# DESIGN EXCELLENCE

## RESPONSE TO STATE DESIGN REVIEW PANEL COMMENTS

CORNER OF PACIFIC HIGHWAY, FALCON AND ALEXANDER STREETS, CROWS NEST NSW  
22.03.2024

Drawing Title
840 Entry Nooks
Entry Nooks

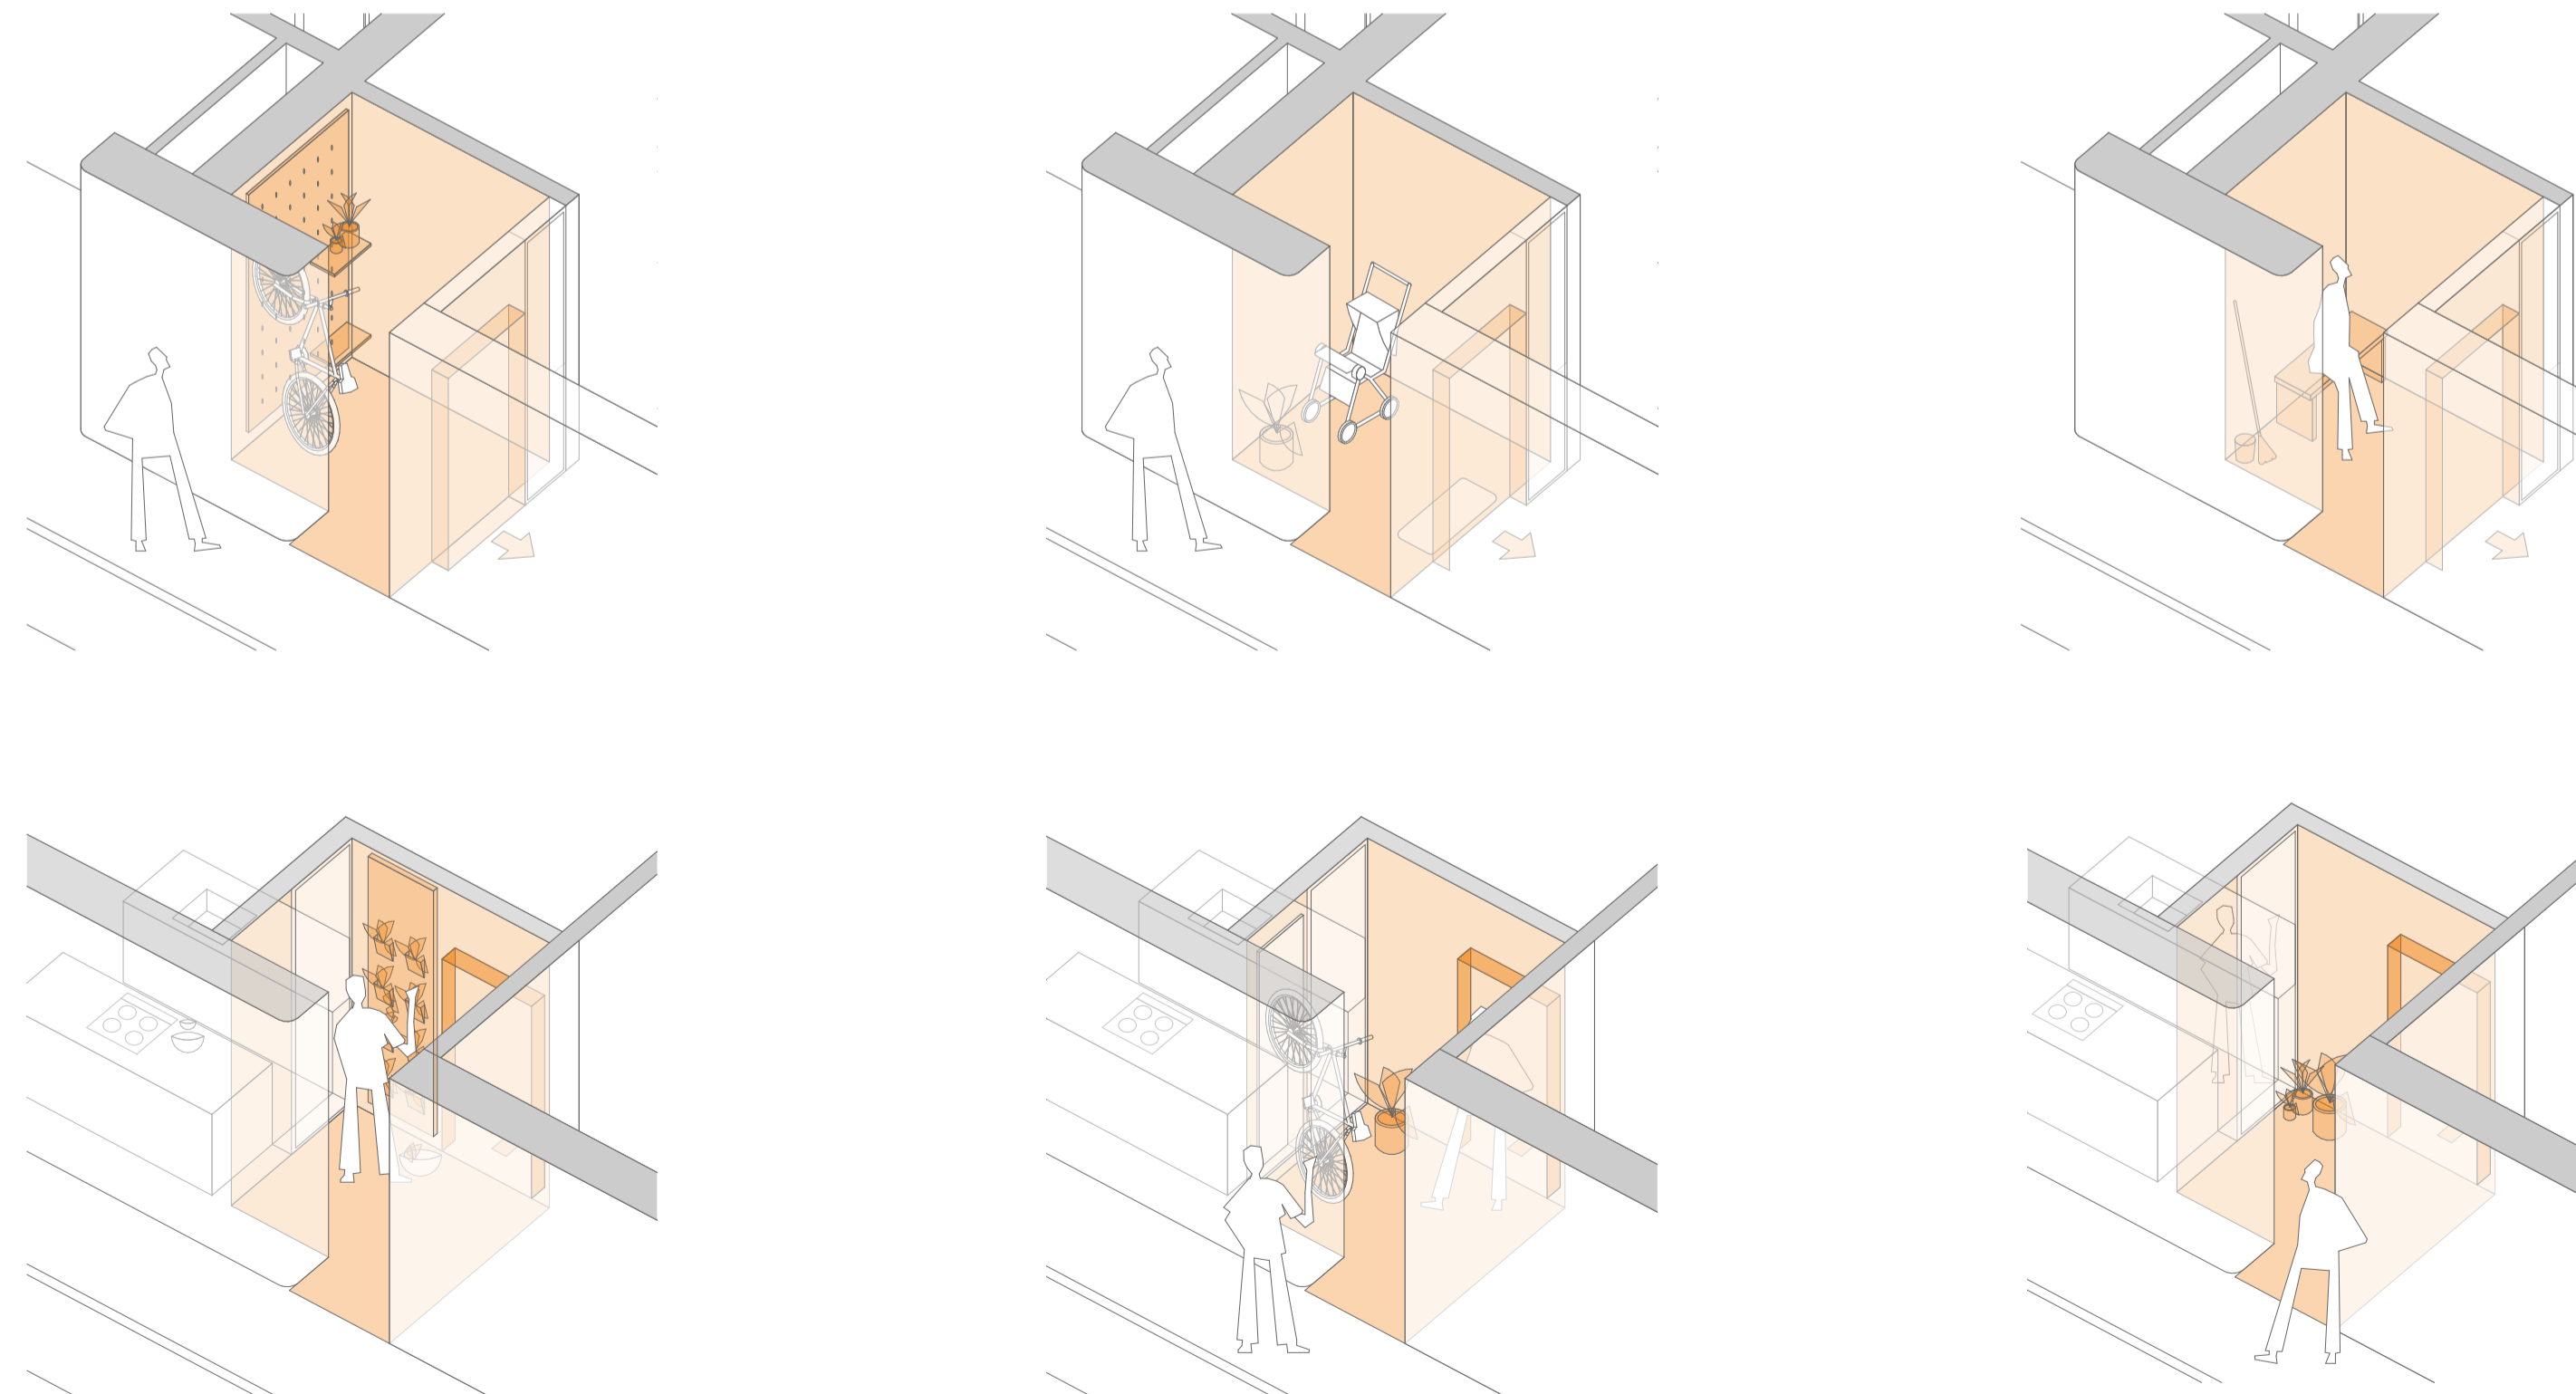
Entry nooks to apartments provide extra space for the storage of bicycles, prams, seating etc.

Client
 Project **FIVEWAYS, CROWS NEST**
 Title **LEVEL 3 PODIUM PLAN**
 Original Size
 Drawing No: **LD-DA110**
 Rev: **2**

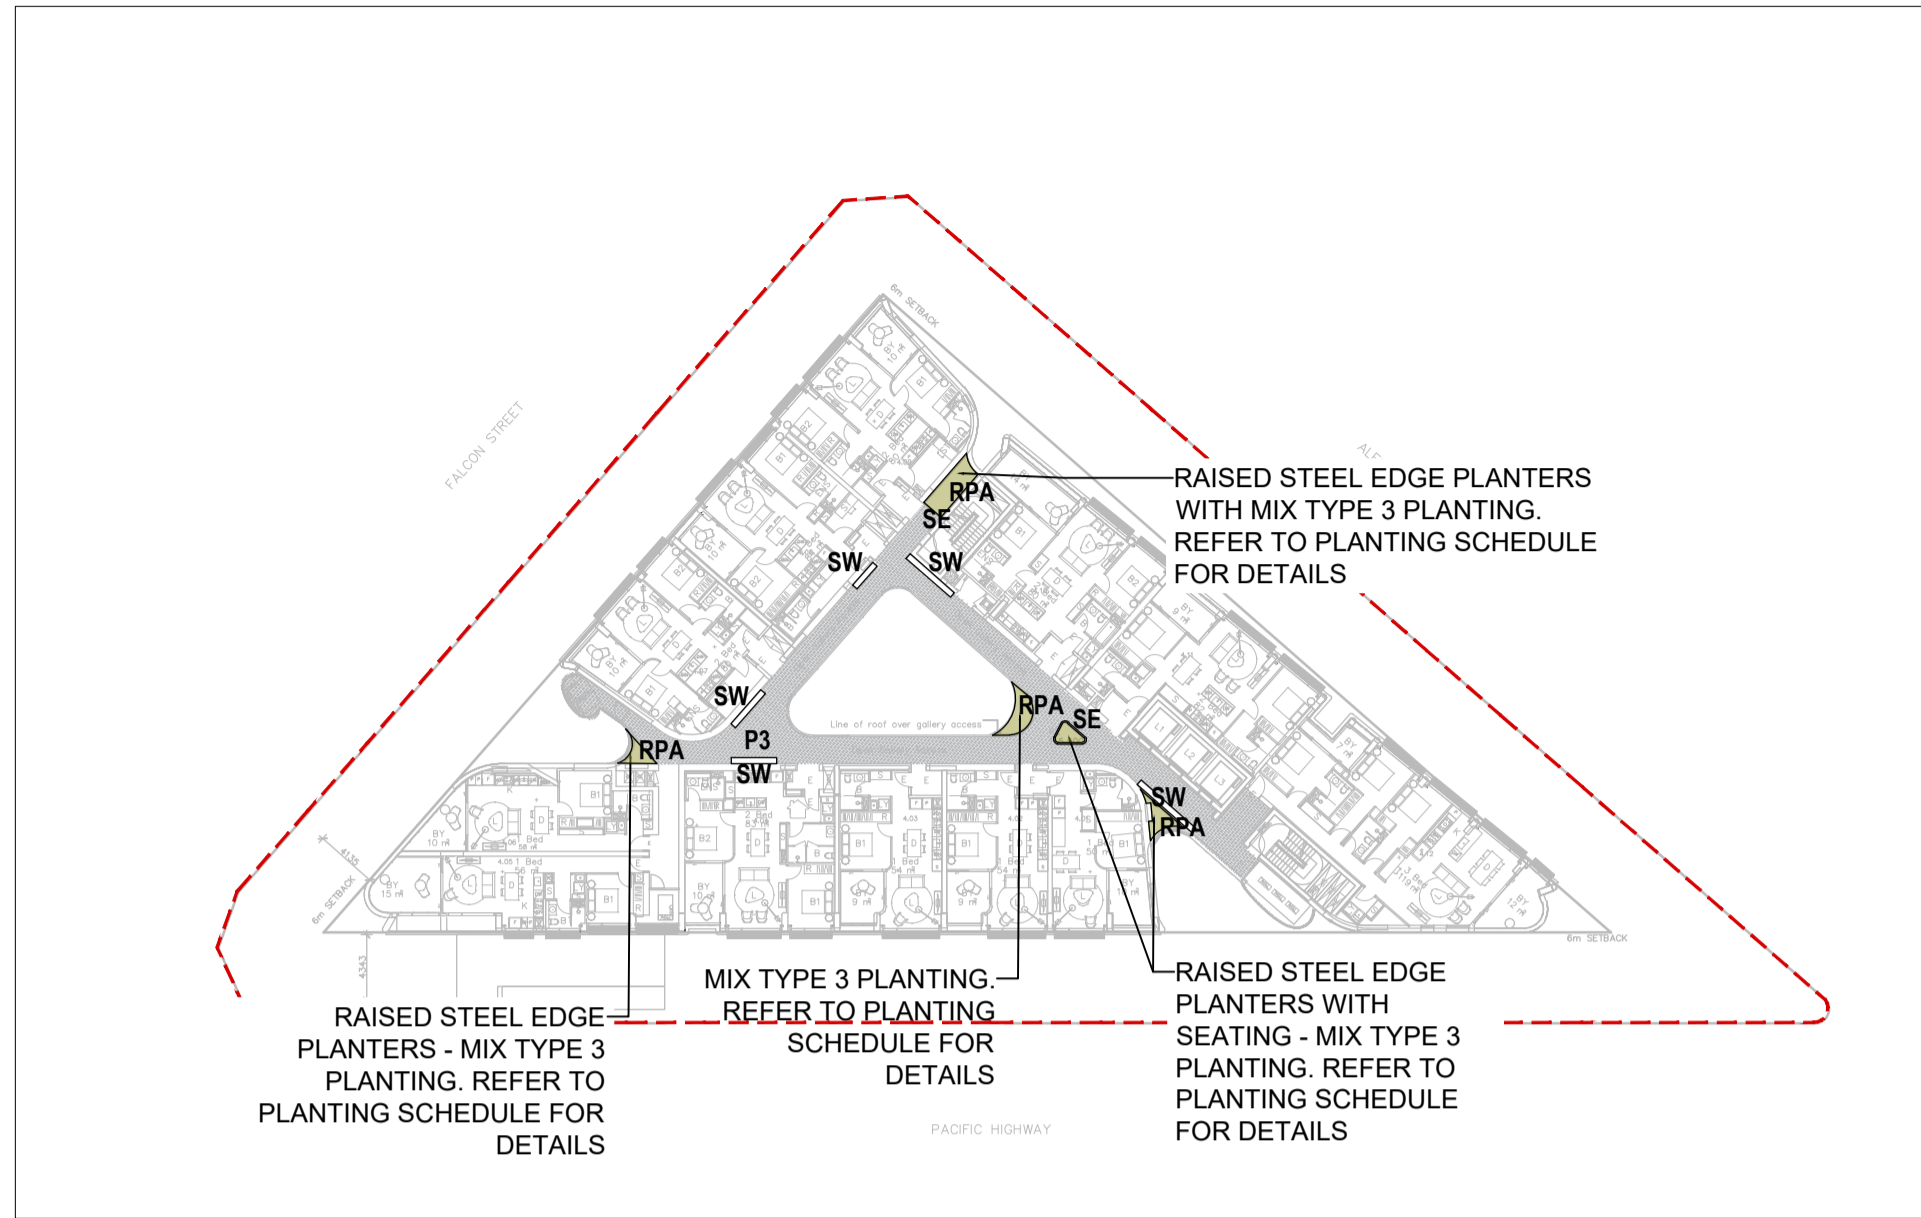
The podium landscape level has been amended so that any planting in undercroft areas is minimised to limited to shade tolerant species.

Additional hard surfaces areas are now included in the central landscape area providing different areas for residents. The quantity of open space provided in the proposal allows a portion to of soft landscaping to be removed and allocated to other uses.
